25th February 2020

Reference: A38 Derby Junctions representation

FIGURE 2.12D ENVIRONMENTAL MASTERPLAN (MARKEATON JUNCTION)

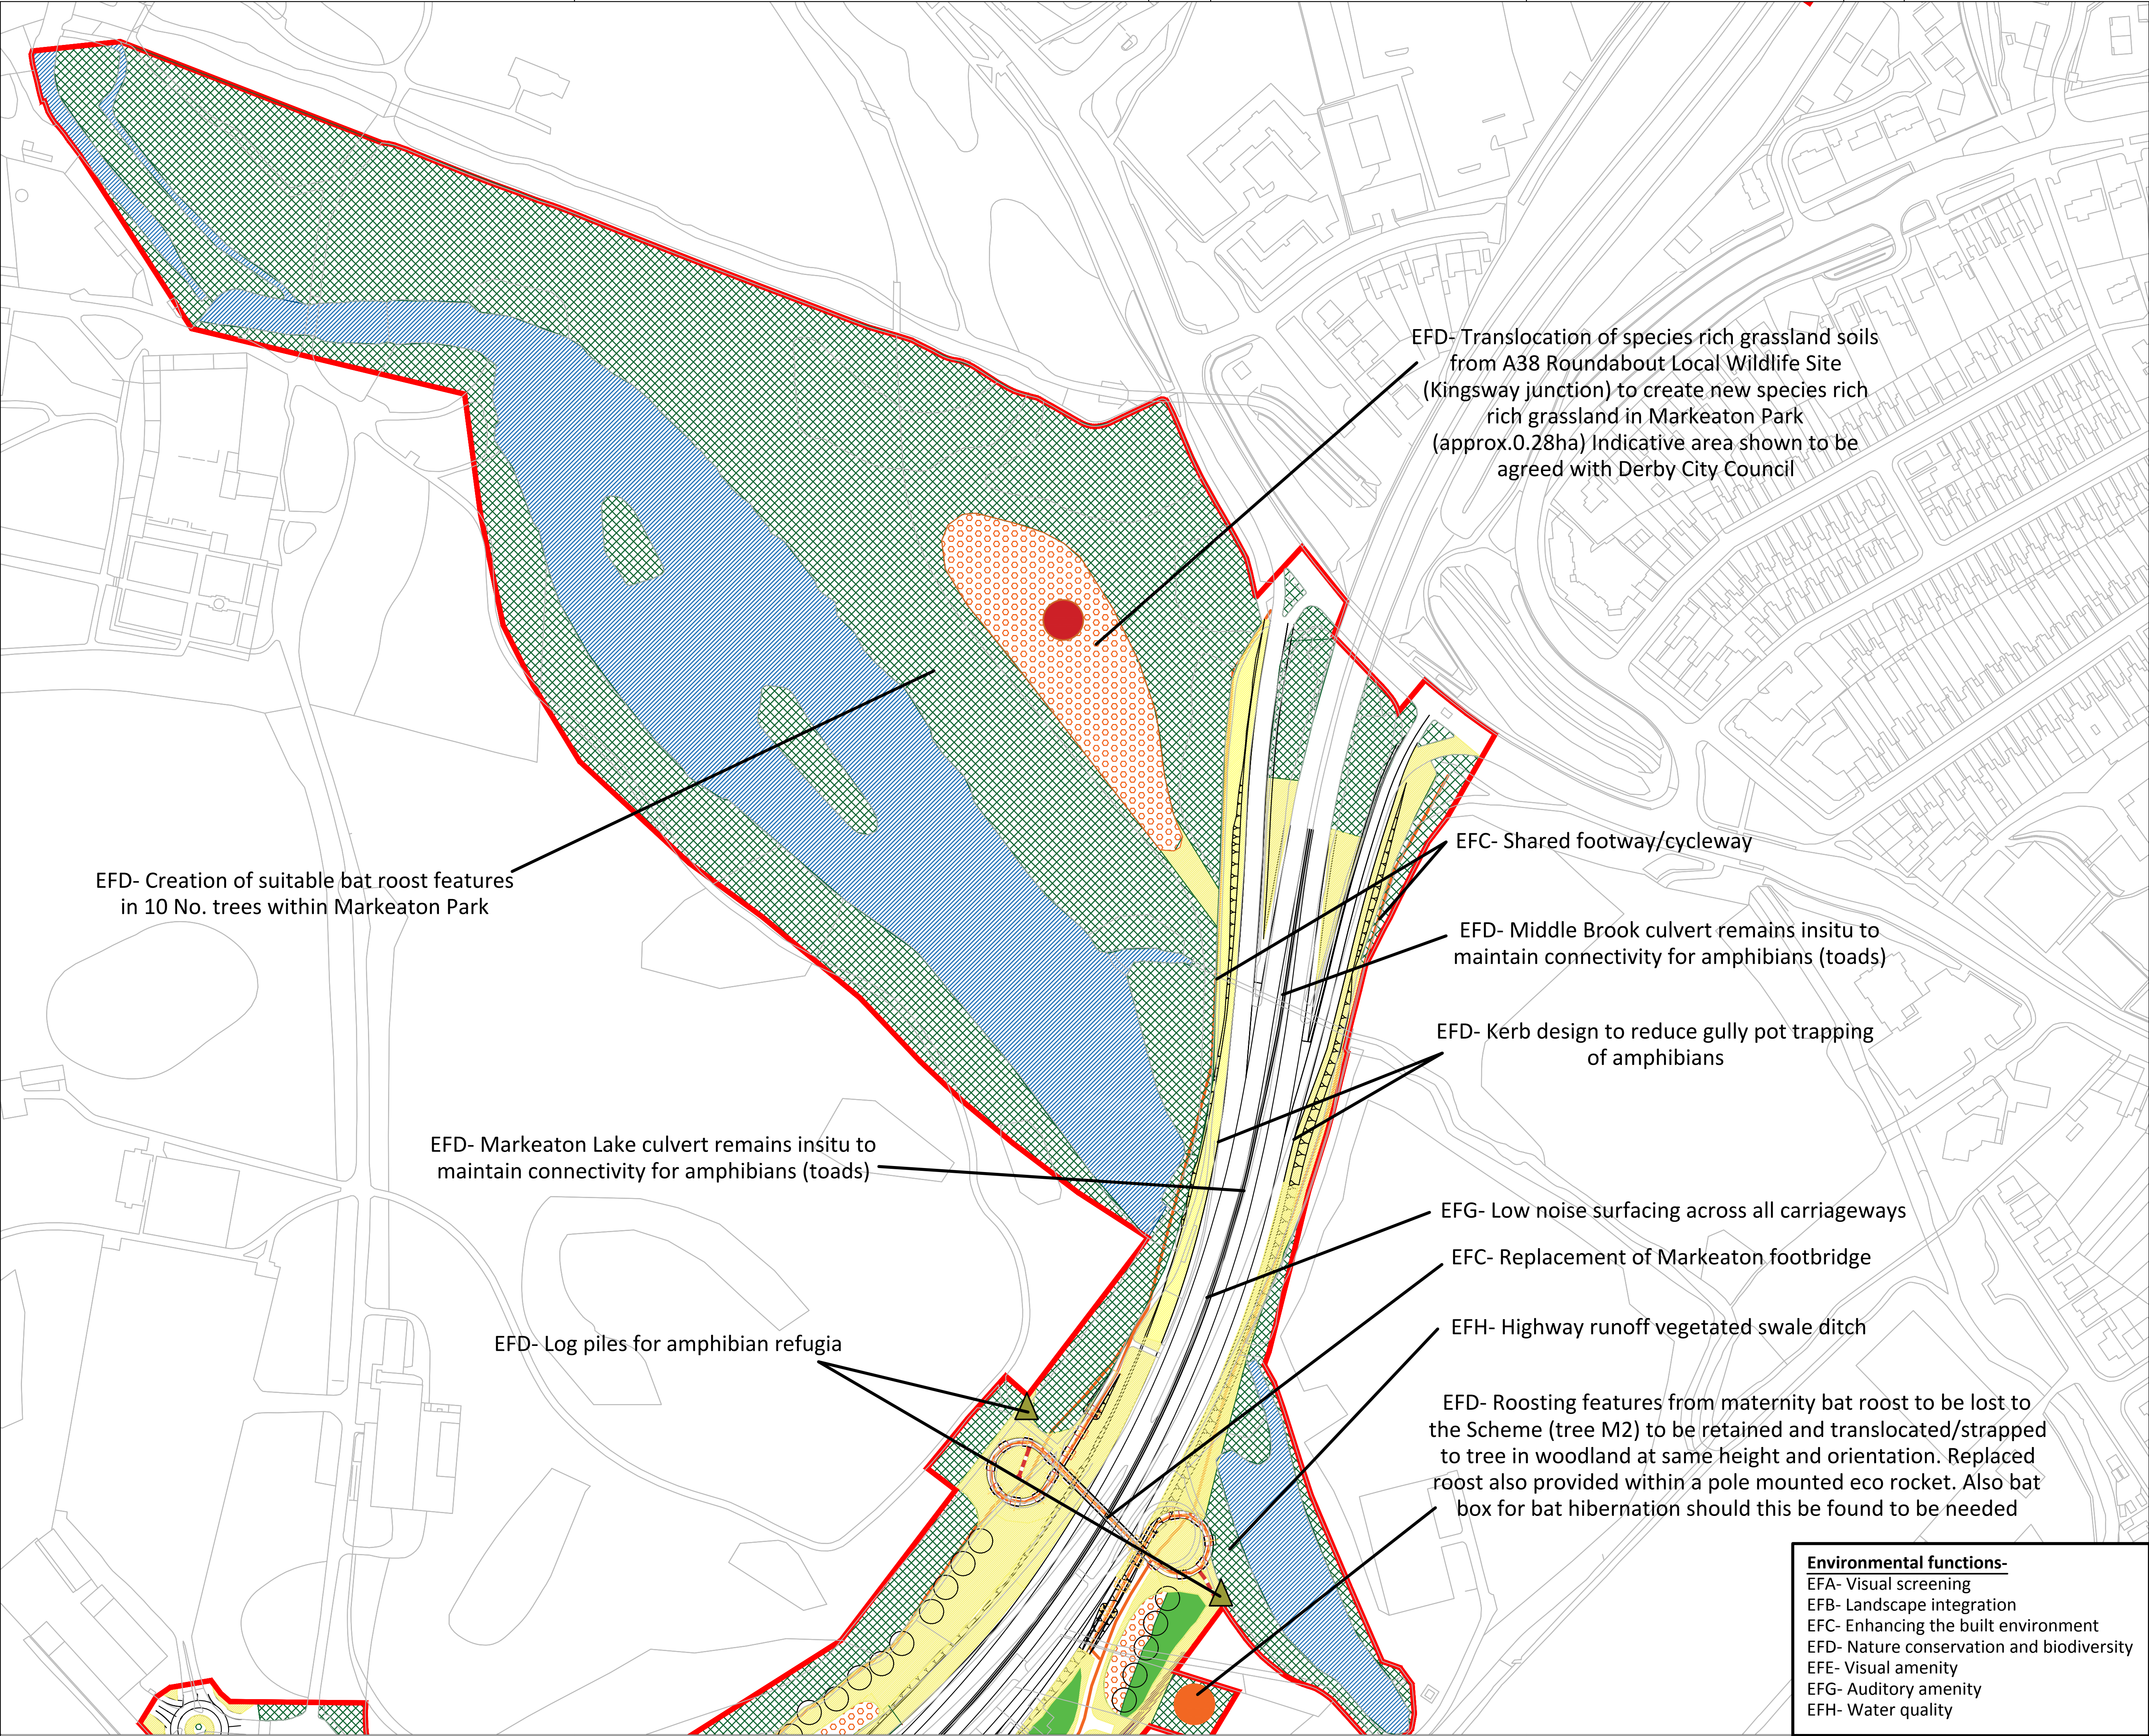
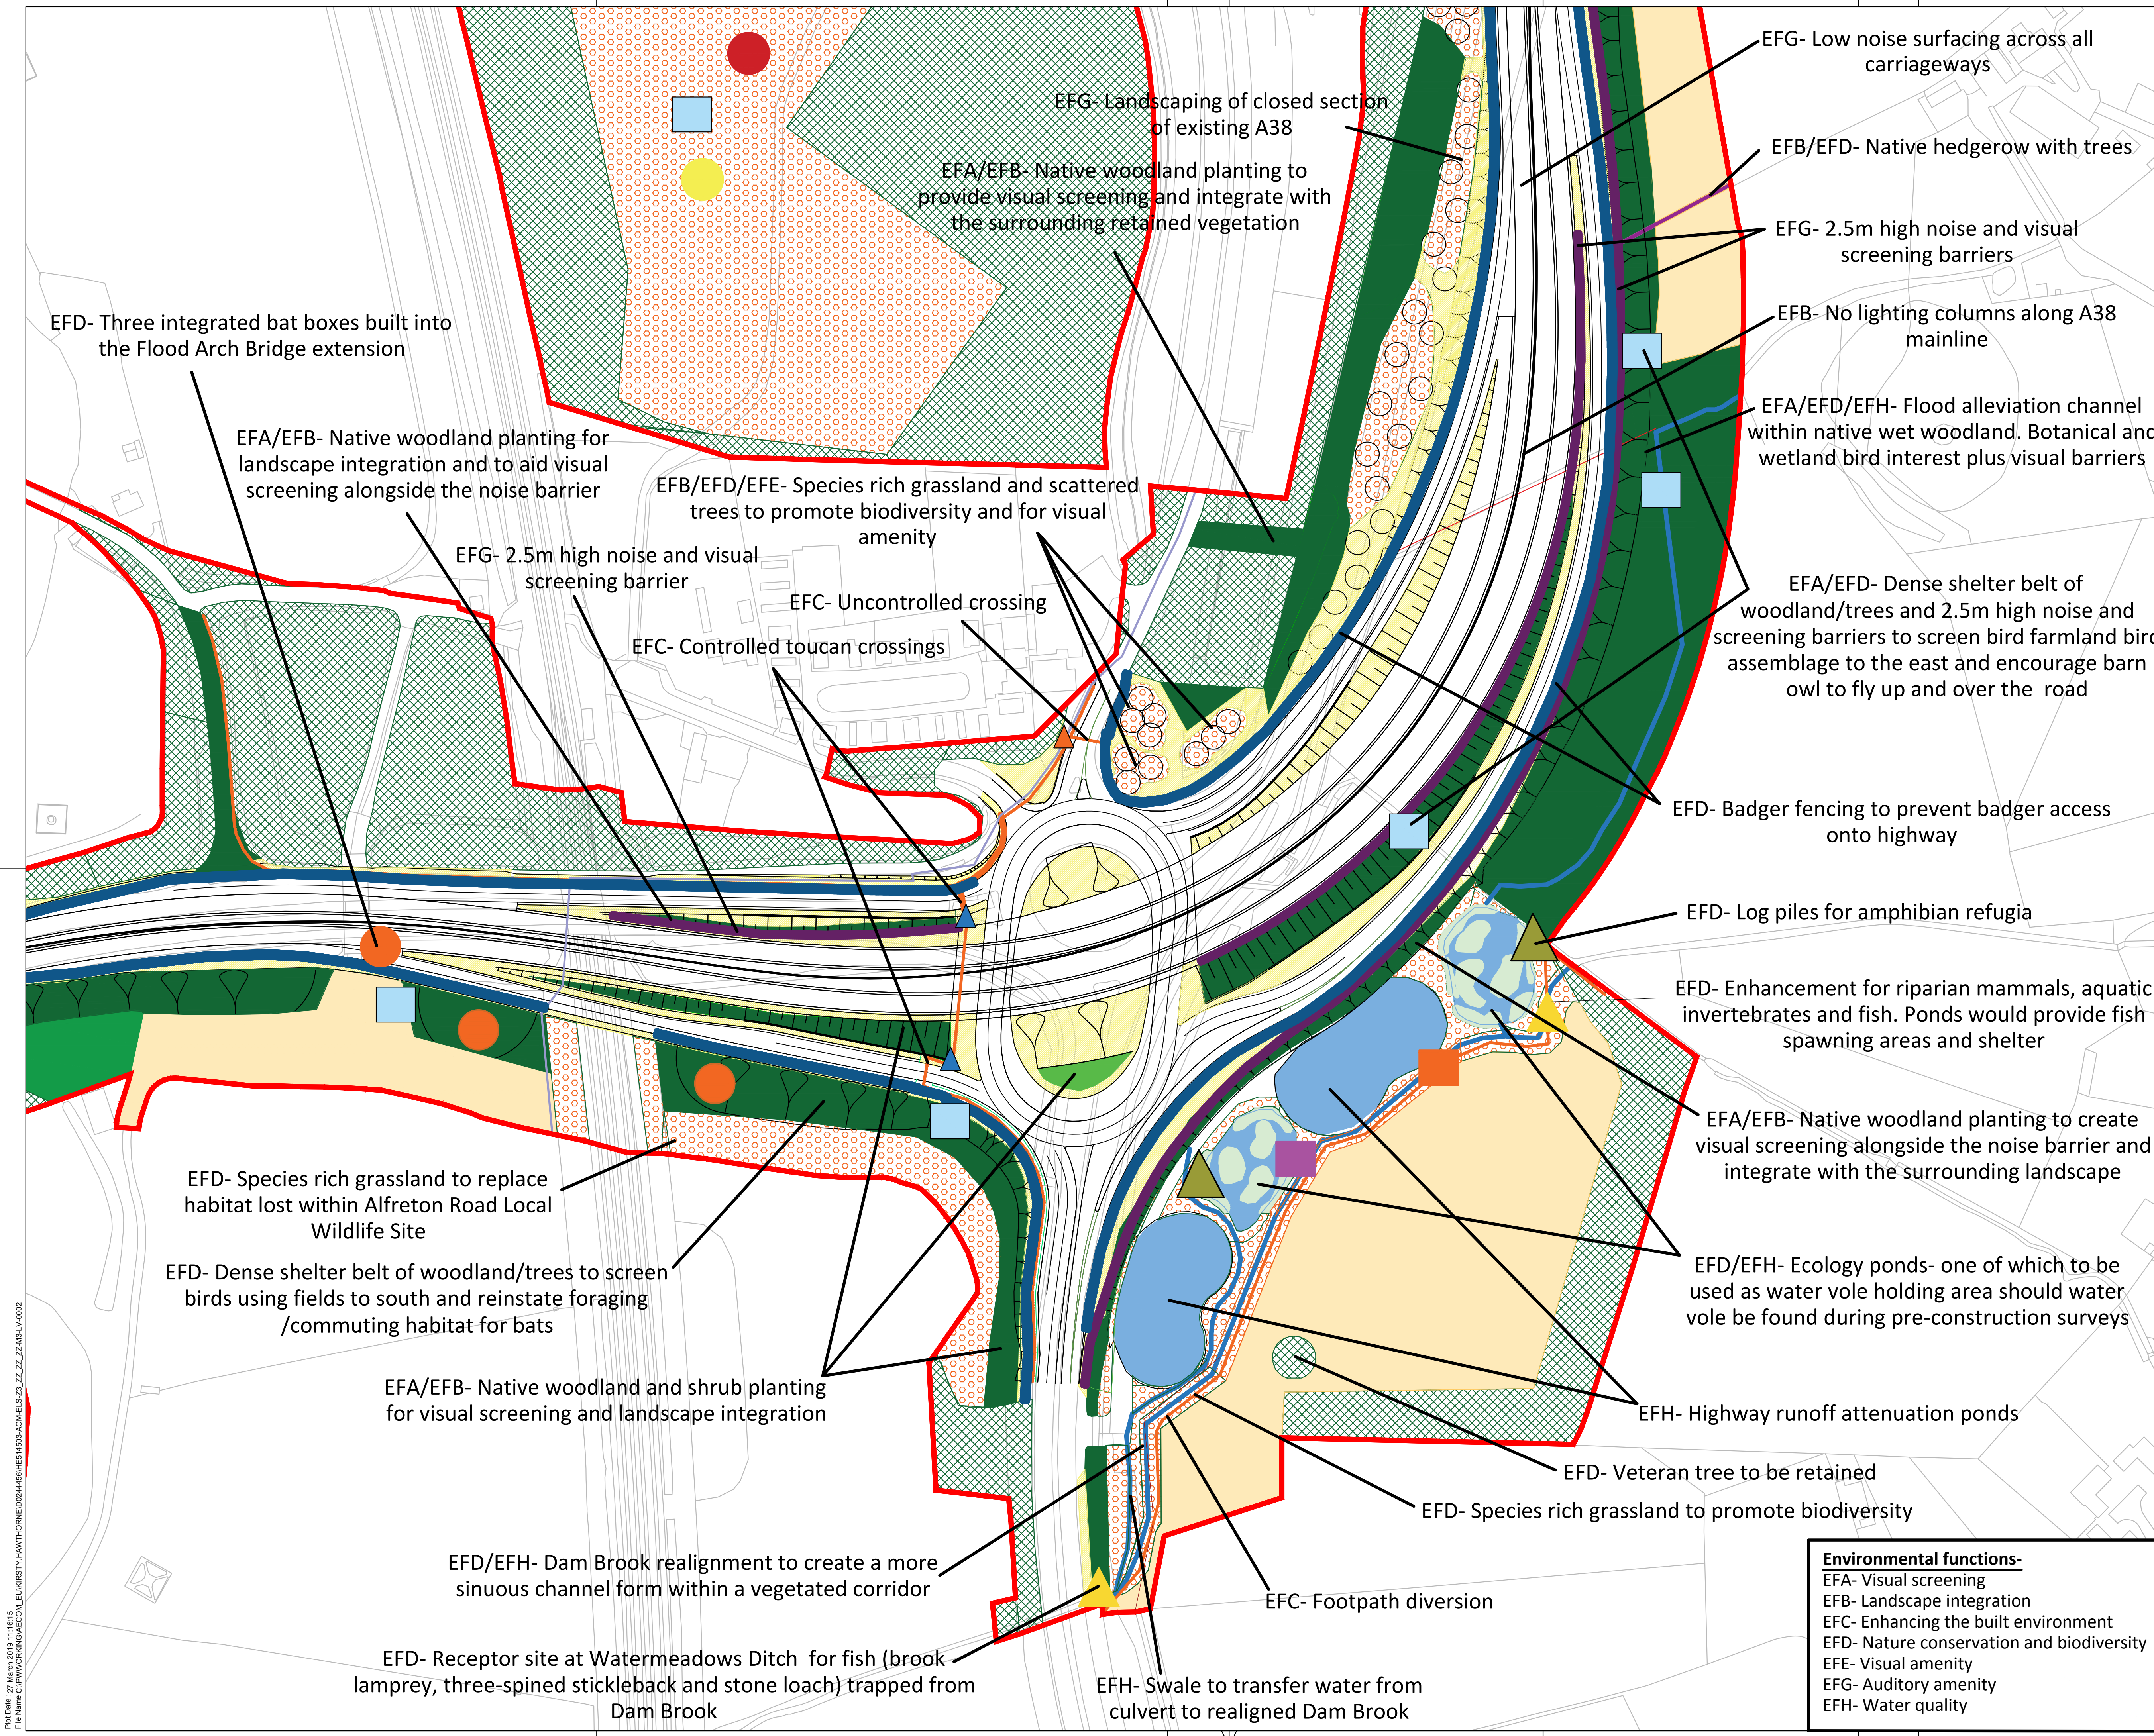
The proposed scheme will result in the loss of a veteran oak tree recorded as T358 within the Arboricultural Impact Assessment Report to facilitate the re-location of the Markeaton public footbridge. Therefore, the Trust would like to lodge **an objection** to this application.

The following scheme will result in the direct loss of a veteran oak tree. It is essential that no trees displaying ancient/veteran characteristics are lost or damaged as part of the project, as any loss would be highly deleterious to the wider environment of veteran trees within close proximity, which may harbour rare and important species.

In summary, the Woodland Trust requests that the veteran tree T358 is retained and afforded a Root Protection Area (RPA) in line with Natural England's Standing Advice.
